Re: J0424-2449
Lot 16 Duncans Creek

The truss drawing(s) referenced below have been prepared by Truss Engineering Co. under my direct supervision based on the parameters provided by Comtech, Inc - Fayetteville.

Job J0424-2449	Truss B02-GR	Truss Type Common Girder	Qty 1	Ply 2	Lot 16 Duncans Creek Job Reference (optional)	I69485366
-------------------	-----------------	-----------------------------	----------	----------	--	-----------

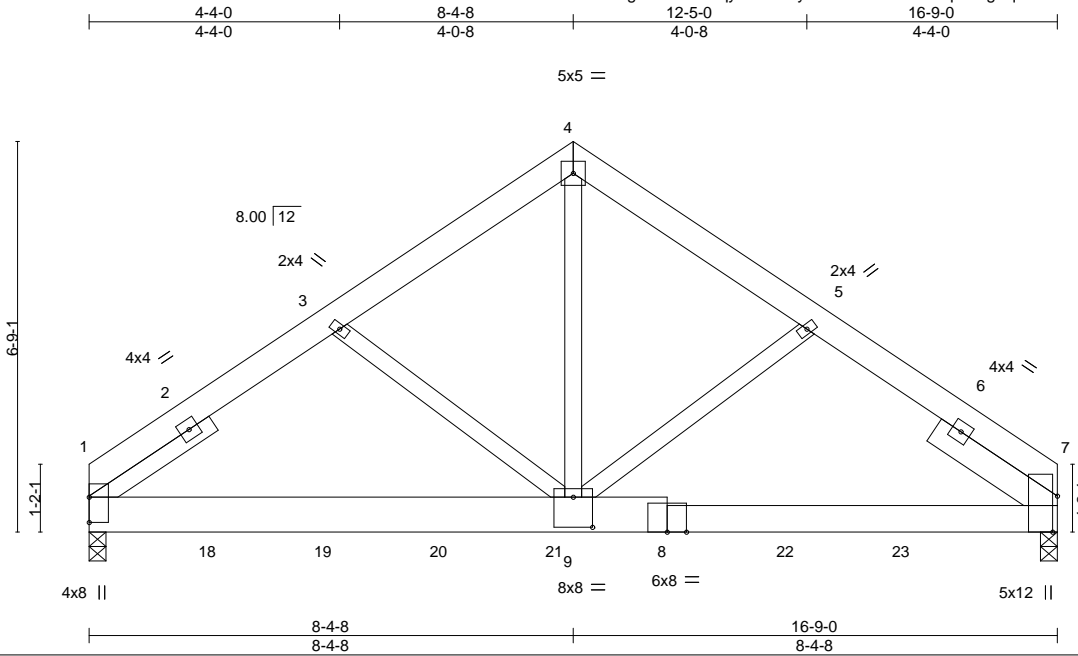
24" WIDE X 3/4" TALL X 3/4" DEEP CORNER BROKE OFF AT JOINT 1
ALONG THE BOTTOM EDGE
NO REPAIR REQUIRED.
